From: Sue Howell
Sent: 22 January 2018 15:33
To: Planning.Responses
Cc: Simon Davis
Subject: RE: Planning Consultation on: Y/74/17/RES

Comment from Greenspace

APPLICATION **Y/74/17/RES**

Site Address: Land At Kings Close Yapton BN18 0EX

PLANTING PLAN
SHEET 2

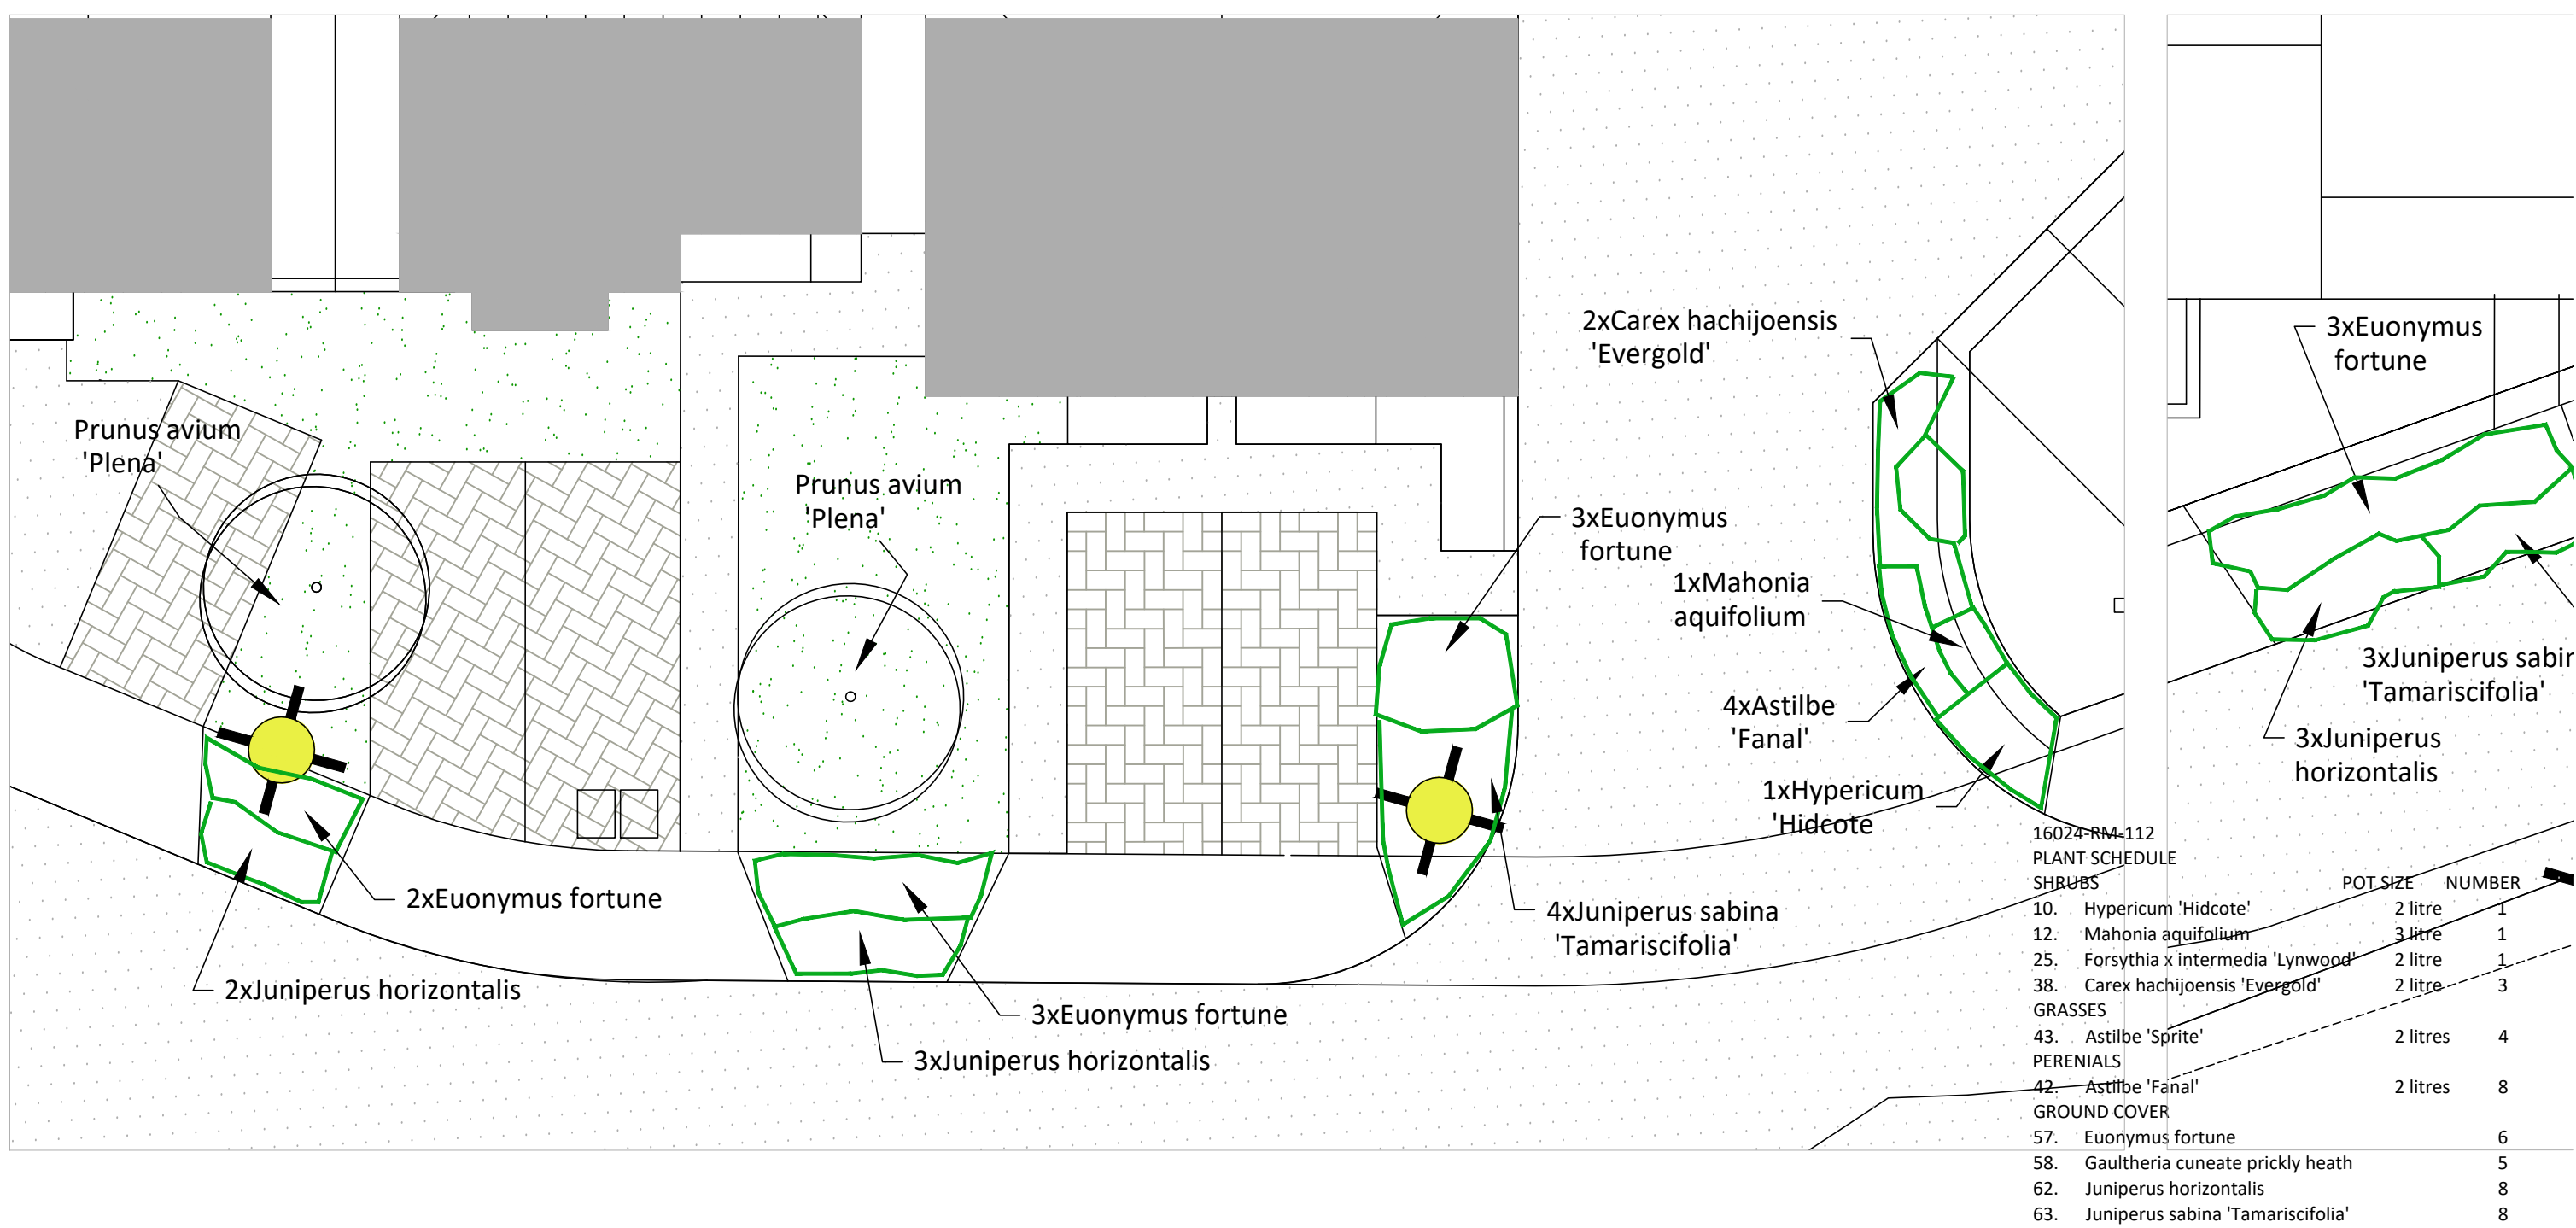
This application has included a detailed landscape scheme with trees, shrubs, grasses, perennials, hedging and groundcover that are both suitable and fitting for location. The 'Site layout-Landscape layout drawing 16024-RM110 D whilst contains details of species type, size and planting density does not include the plant quantities being proposed, which we would recommend are a requirement in plan form.

Our recommendation therefore would be that this drawing is amended to show actual quantities in location rather than just detail of the variety for location.
